Planning Officer: Claire Potts / Ms Louisy-Johnson

Planning Application Ref: AL/87/21/PL

Location: Oldlands Farm, Newlands Road, Bognor Regis, PO22 9FJ

Description of works: Erection of a warehouse (Use Class B8) with ancillary office, associated vehicle parking, van storage, plant, ancillary structures, lighting landscaping and infrastructure works including earthworks to facilitate flood compensation area. This site may affect listed buildings, may affect the character & appearance of the Shripney Conservation Area, is a Departure from the Development Plan, affects a Right of way & is in CIL Zone SP3 (Zero Rated) as other development

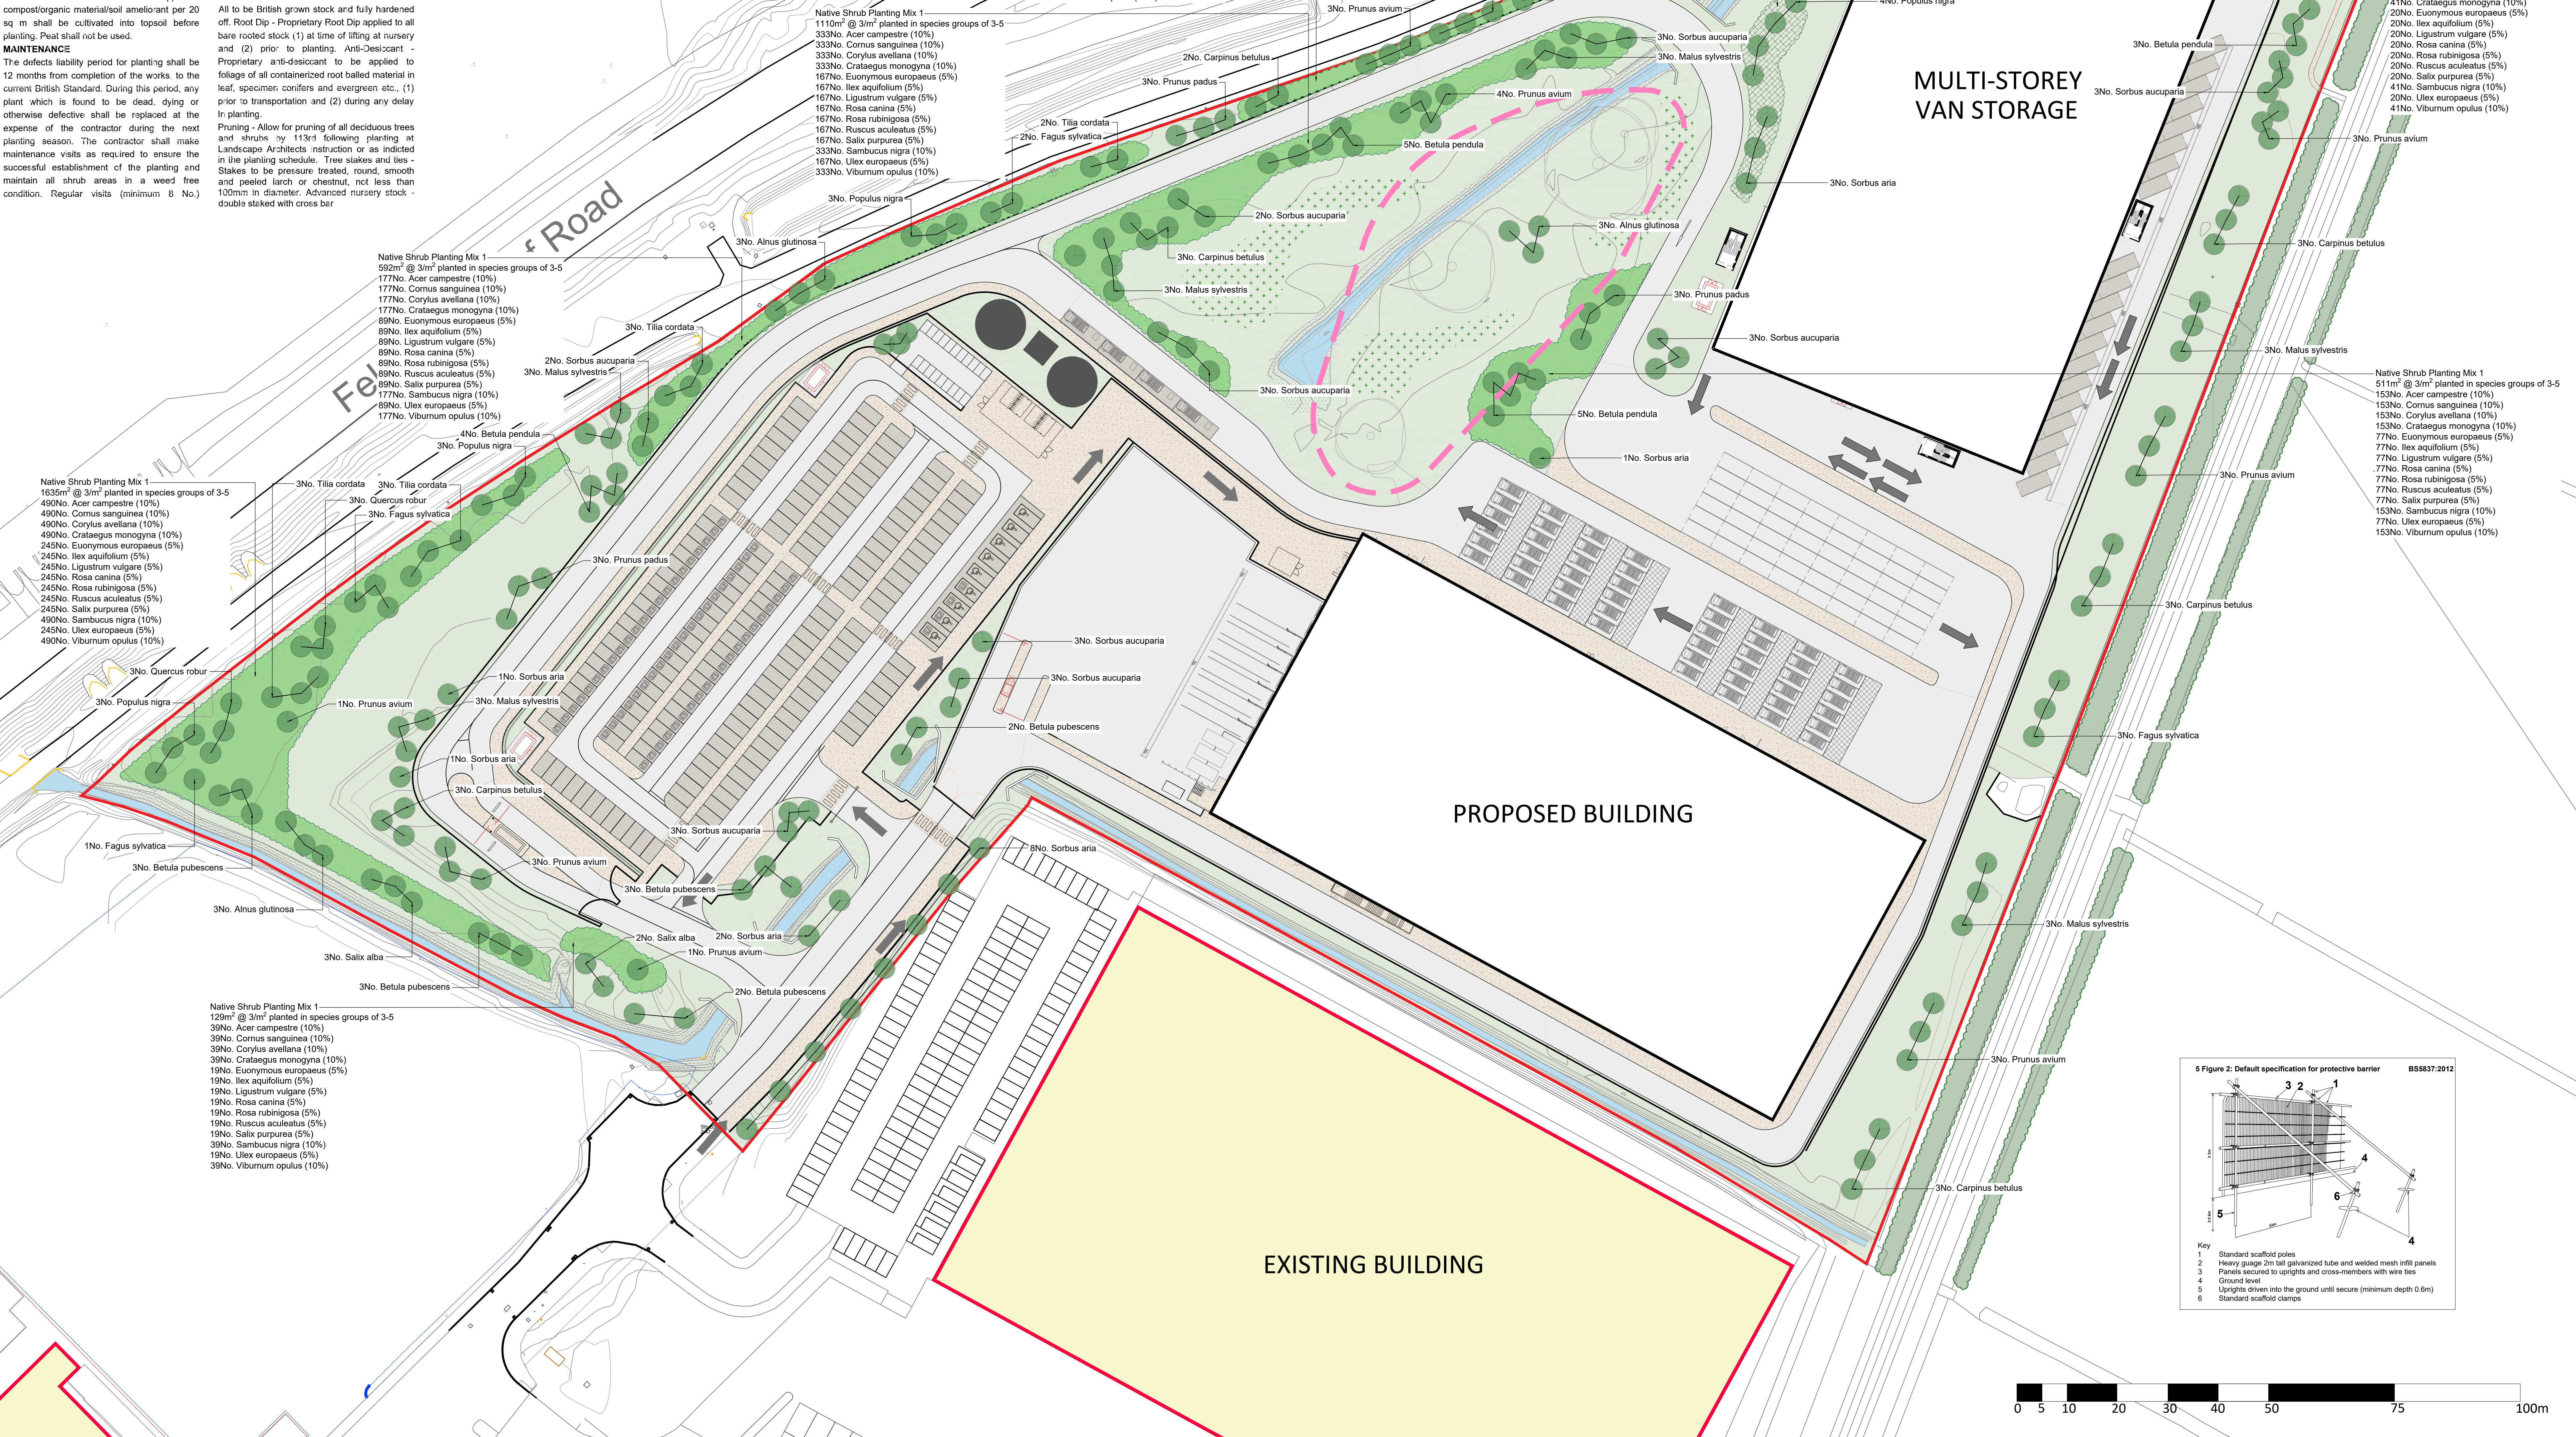
- I have considered Landscape Planting Plan 05-991-701 and Proposed Site Plan 21023-ASA-V0-XX-DR-A-PL03-(S2-P3) REVP3 to gain some understanding of the proposed relationship between retained trees and built form/infrastructure. Although the broadly defined extent of protective fencing is encouraging, we require both a dedicated (stand-alone) Tree Protection Plan (TPP) showing those trees' crown spread and root protection area in direct relation to proposed layout and associated site-specific Arboricultural Method Statement (AMS). Those are essential requirements at detailed application stage.

Figure 2: Illustrative Site Layout Plan

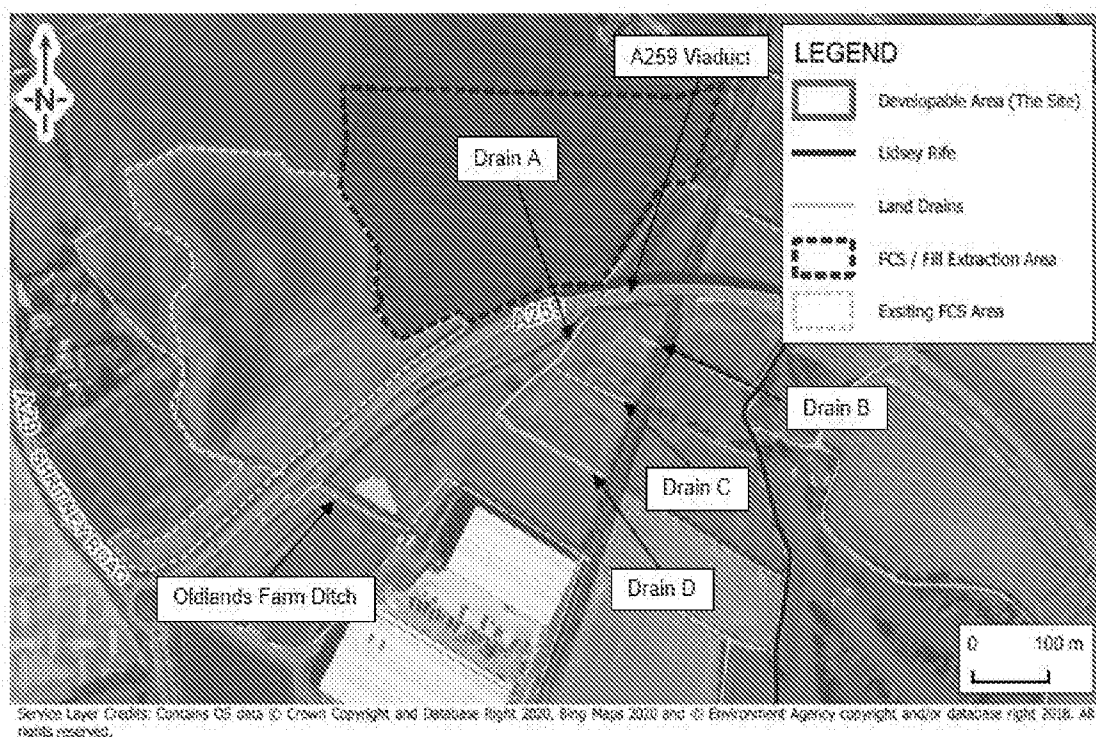
- Infill of existing ditches is proposed across the site (see para. 3.2. of Technical Note from Herrington Consulting Ltd, 27 July 2021, Rev 1). We need to understand whether any such work (or improvements to existing or creation of new watercourses) might occur within or proximity to the RPA (+2m buffer zone) of preserved trees. Confirmation and details to be provided in advance and to our satisfaction. Where there is a significant risk of damage to those trees arising from such operations, then an alternative strategy should be proposed.

- Proposed Site Plan superseded by REVP7 with no obvious additional implications for retained TPO trees.
- There remains no approved surface water drainage strategy. Location of attenuation basin/pond, culvert headwalls/railings, infill/creation of open ditches and any alteration of ground levels – must not occur or facilitate adverse conditions within influencing distance of retained trees. Where those features may be shown abutting (and so theoretically outside of) RPAs, will likely impact negatively on trees once the work is underway – hence the requirement for a 2metre buffer zone.
